Please ask for: Nicola Moore
Email: nicola.moore@arun.gov.uk
Telephone: Ext 37944
Our Ref: P/60/22/PL
Your Ref:
Date: 25th April 2022

Application for Planning Permission

Development: Replace existing conservatory with front porch, single storey rear extension and dormer windows. Extension of existing garage and part conversion to tourist accommodation.
Location: Grey Barn Church Lane Pagham PO21 4NX

SITE PLAN
1:500@A3

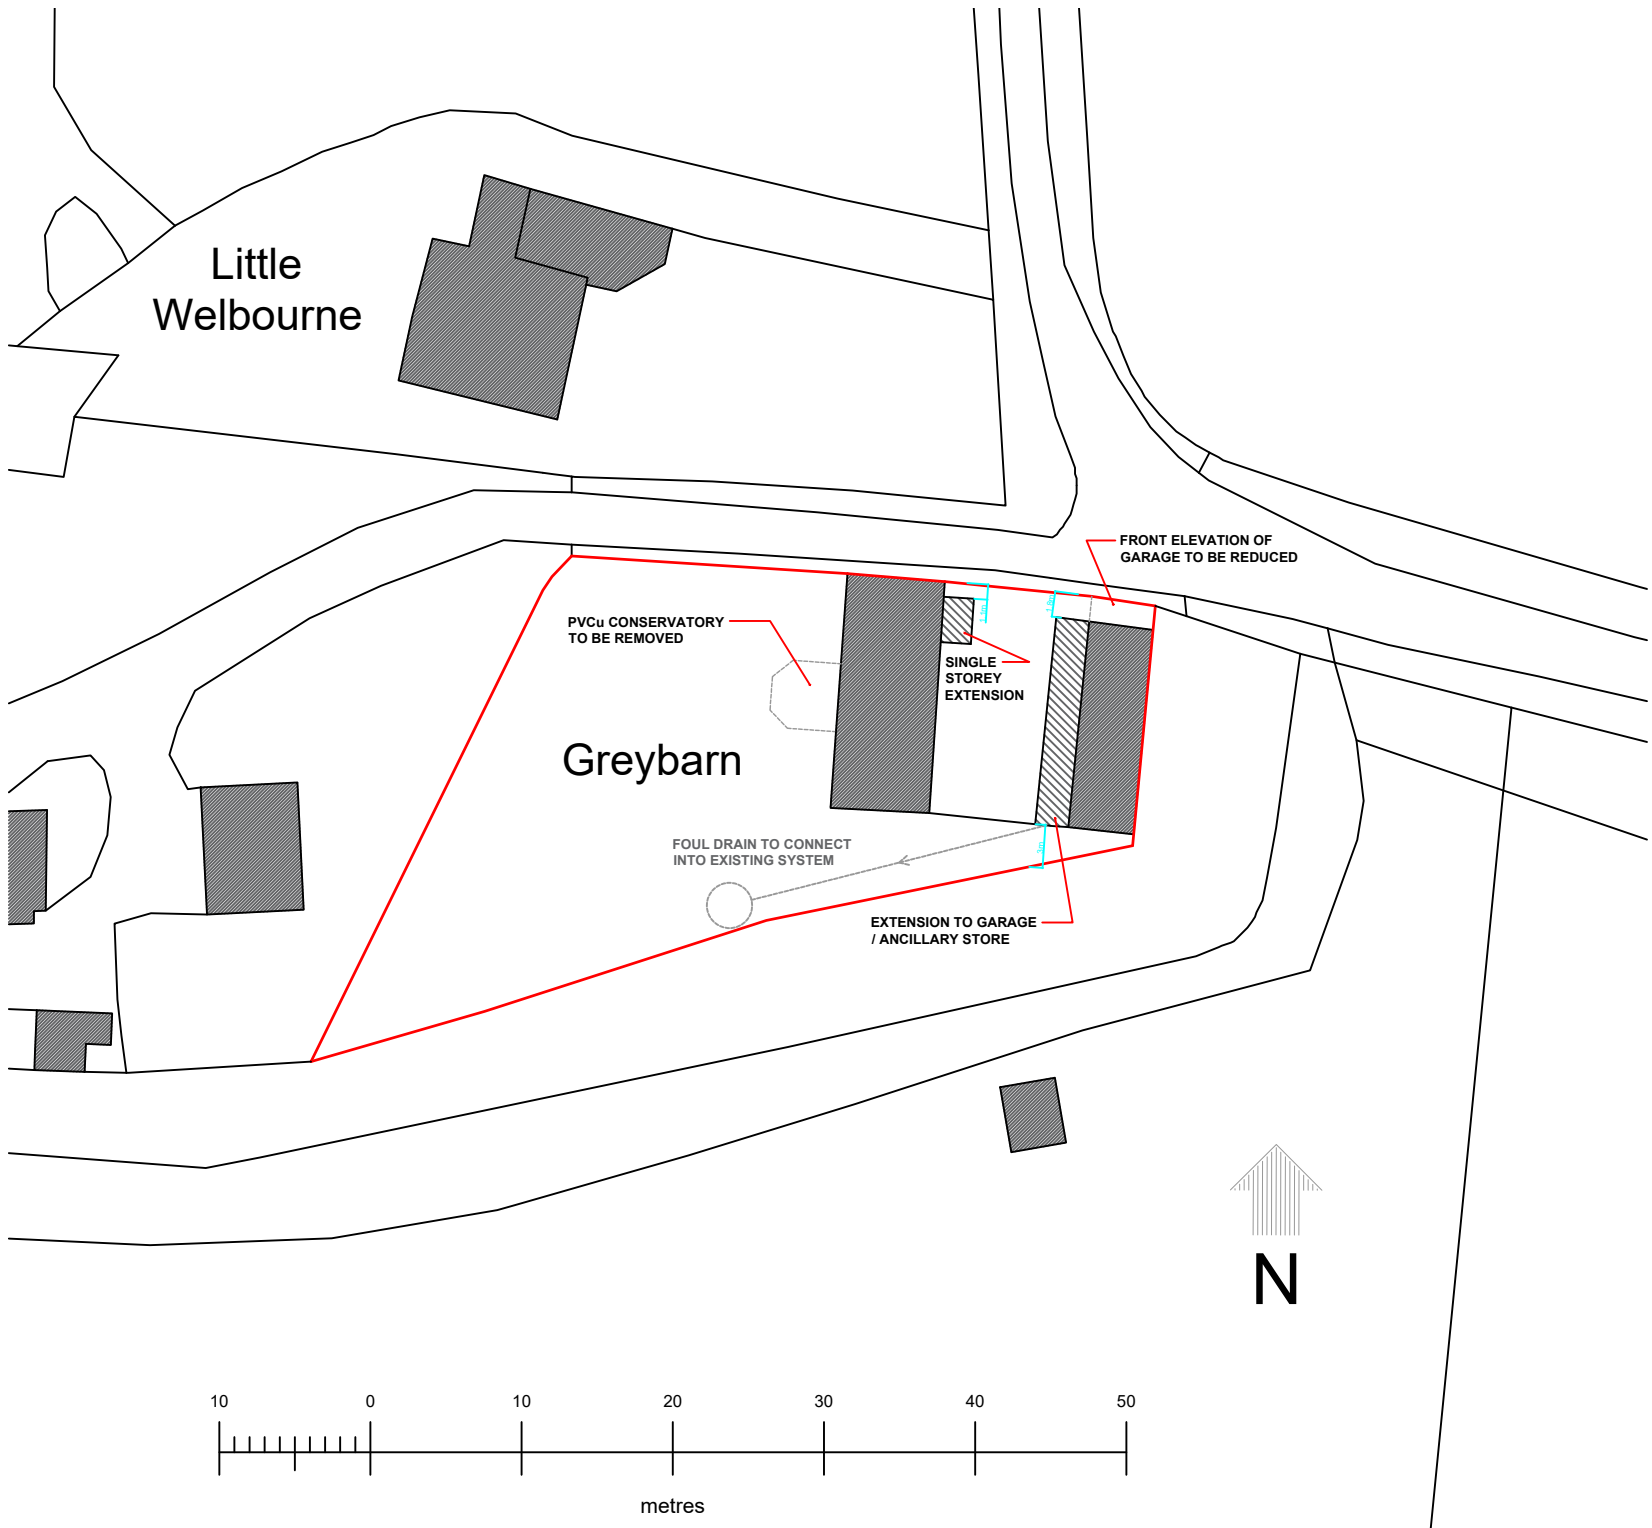
Block Plan

The Block Plan should include distances to boundaries from the proposed development and a North Point. Please amend accordingly and re submit. Further details of what must be included on the plan can be found in the Validation Requirements List.

LOCATION PLAN
1:1250 @ A3

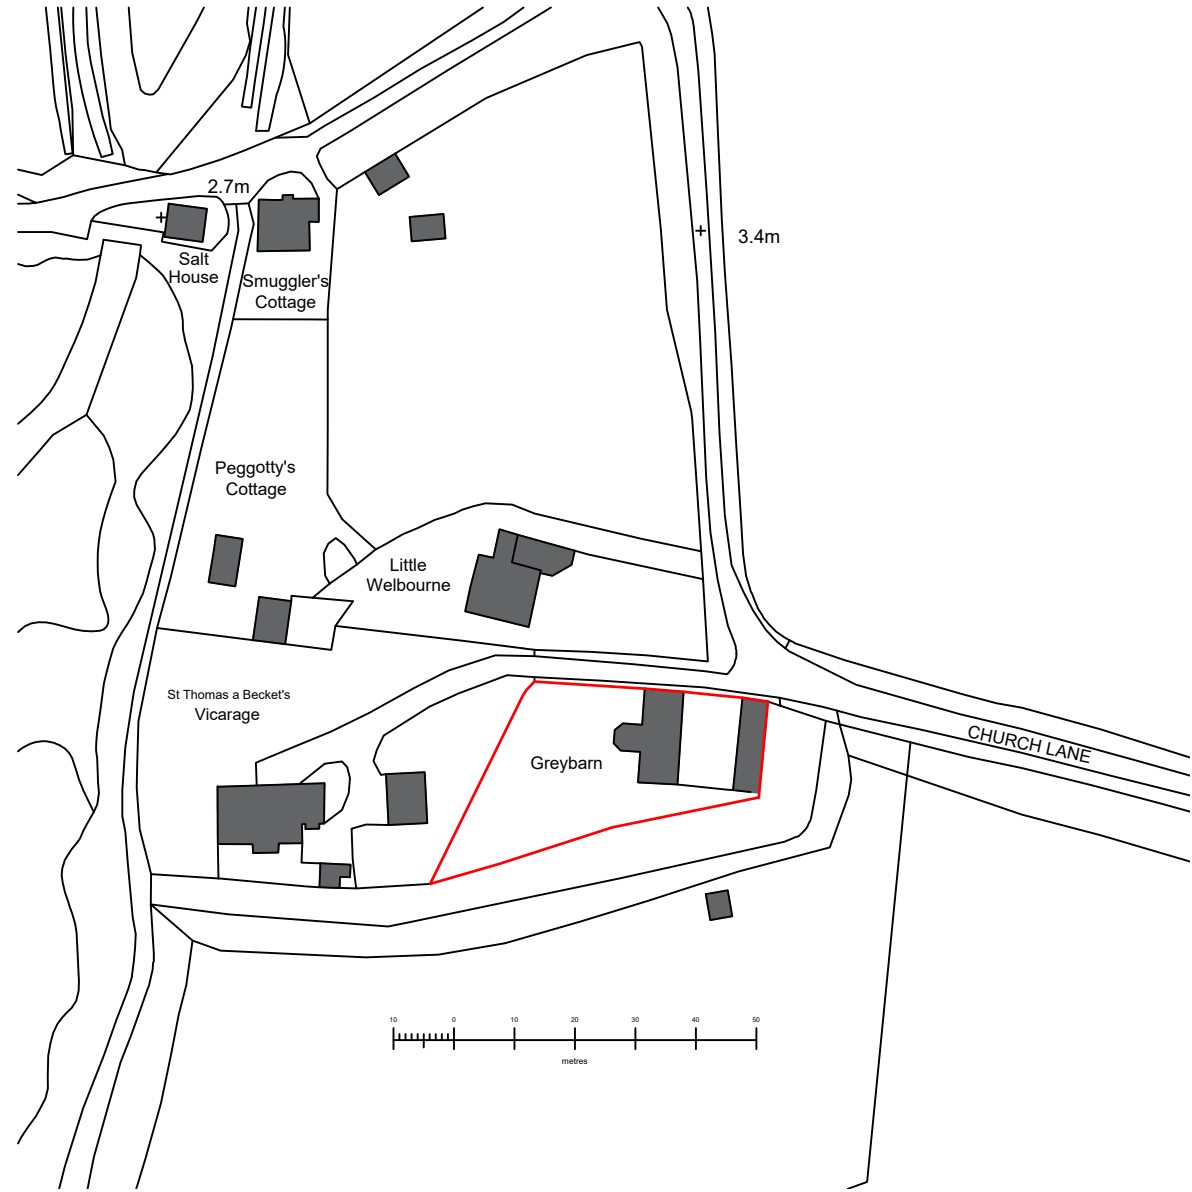
The Location Plan should include at least one named road and a North point. Please amend accordingly and re submit.
